South Holland District Council

**Re: Reserved Matters Application for Residential Development of 60 Dwellings
Land Off Nightingale Way Sutton Bridge – H18-1167-19**

We refer to recent email communications and in particular your email dated 2nd January 2020 raising various comments and queries. This letter responds in detail to the points raised in the same order presented within your email.

HOUSE TYPE: 3bdd_A

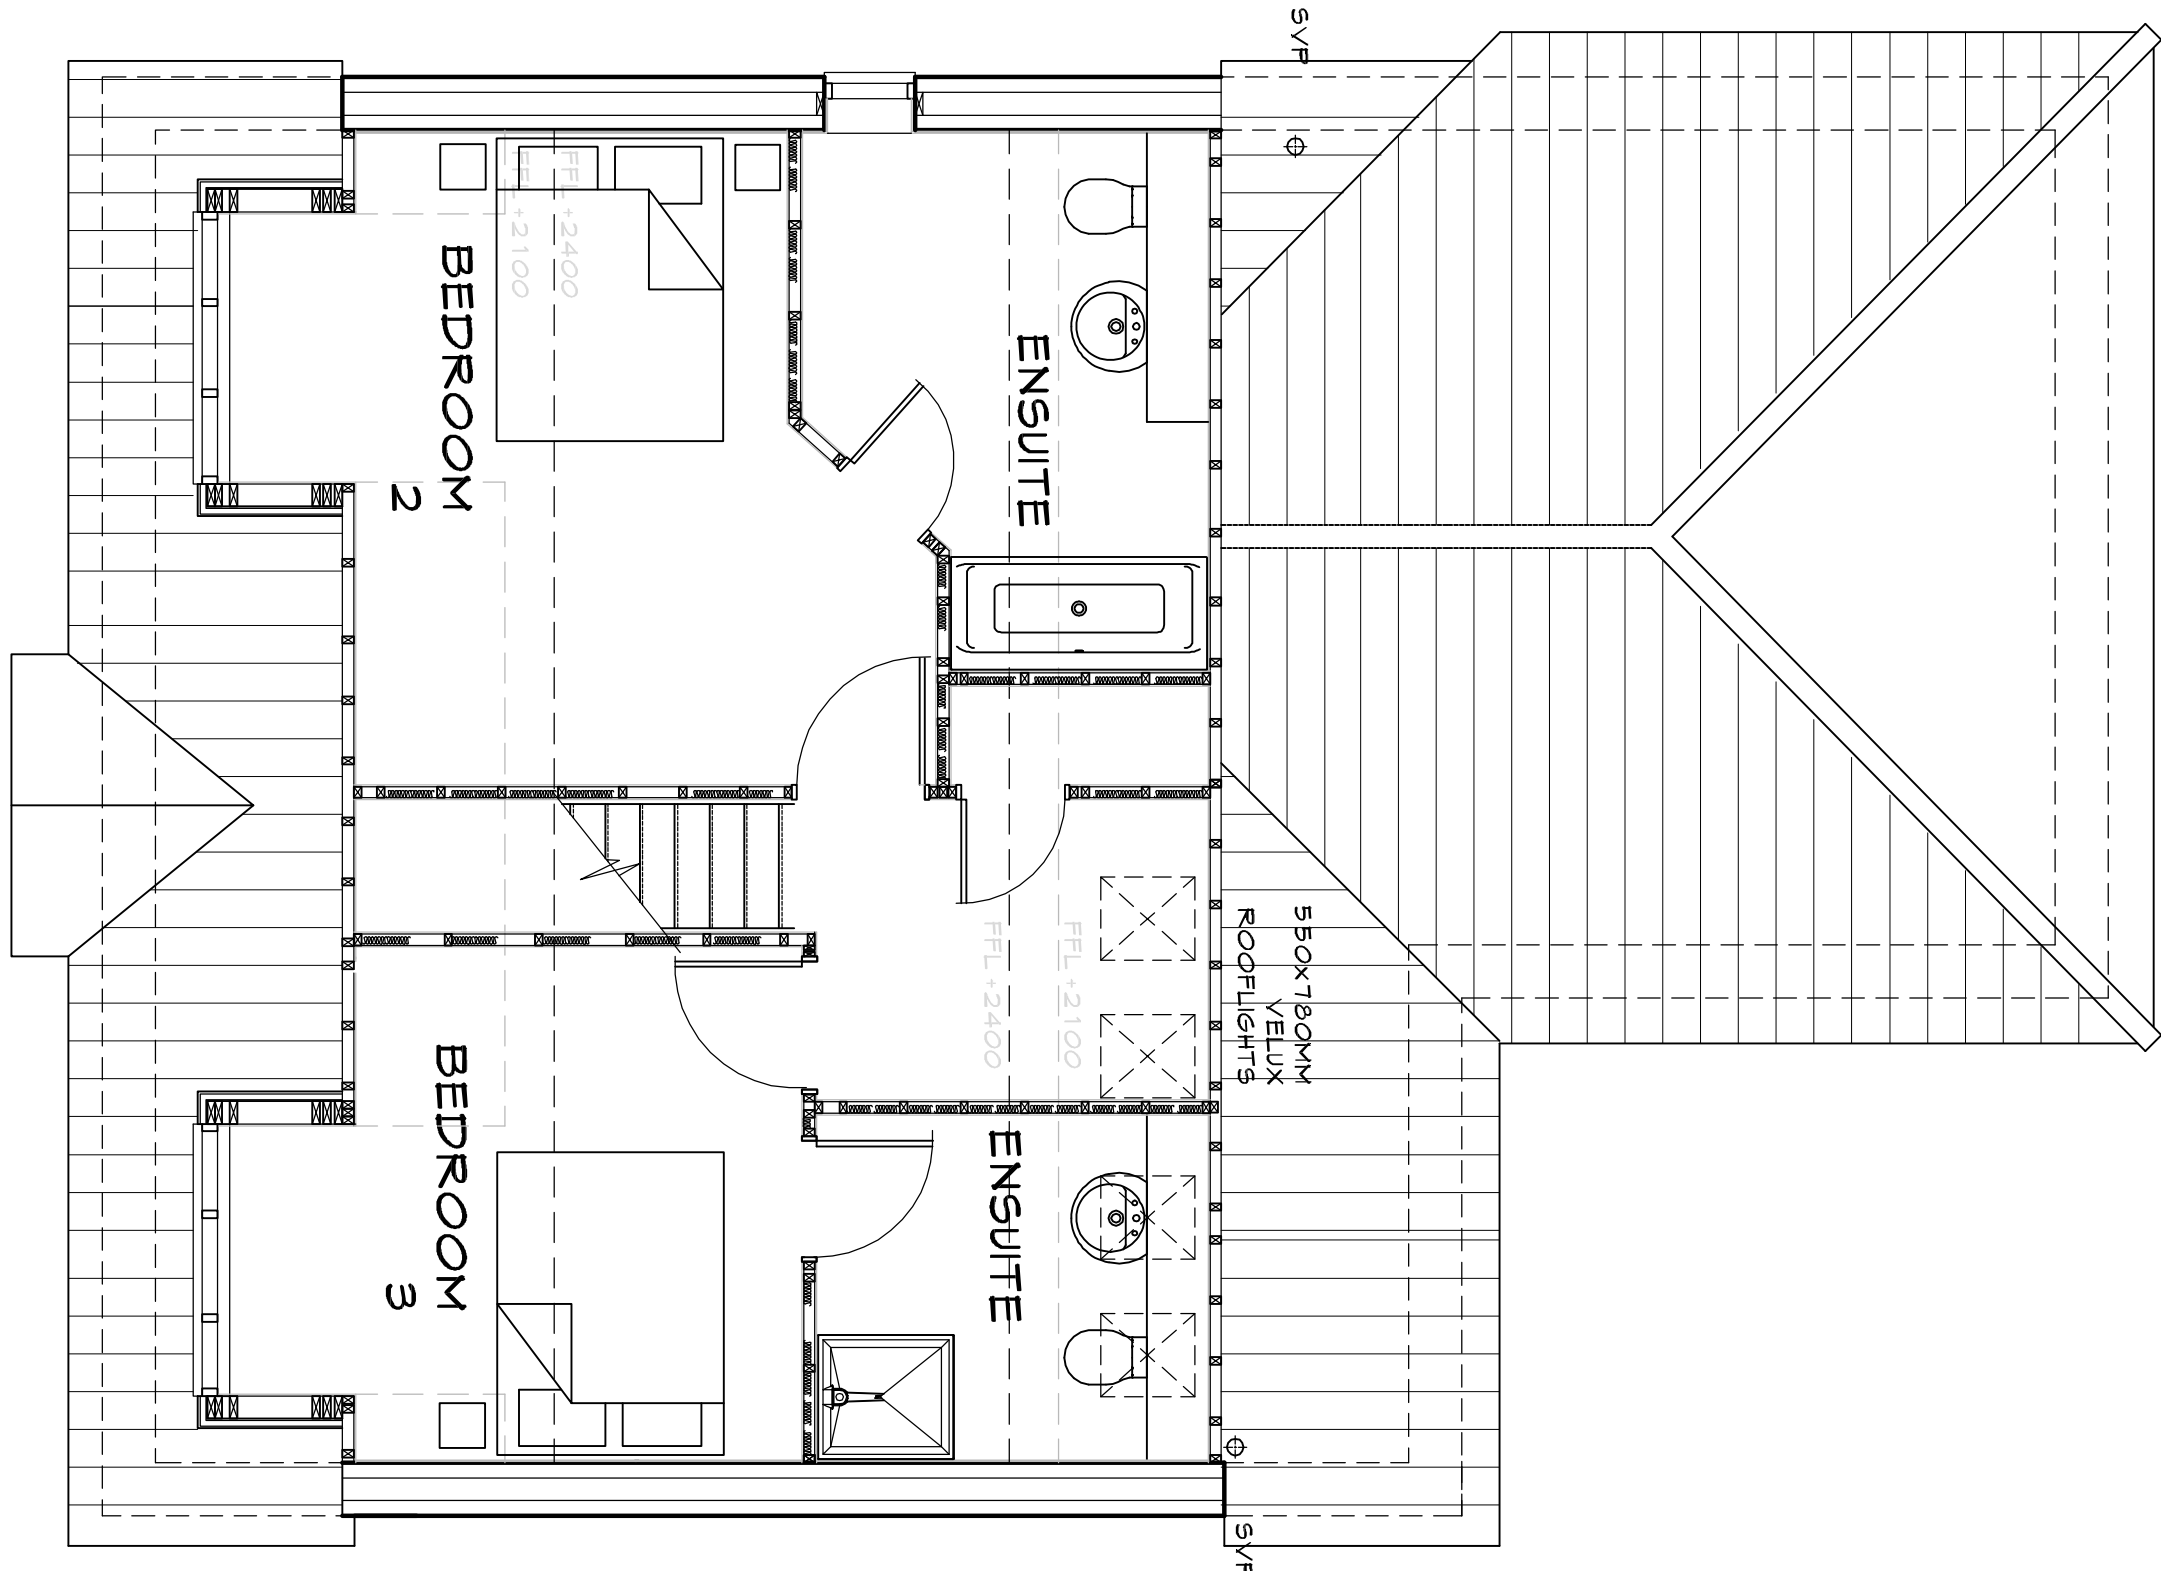
7.01 The discrepancies noted have been rectified and revised drawings are now enclosed for house designs 1b2s_A/2b2s_B, 3bdd_A and 3b2s_AA.
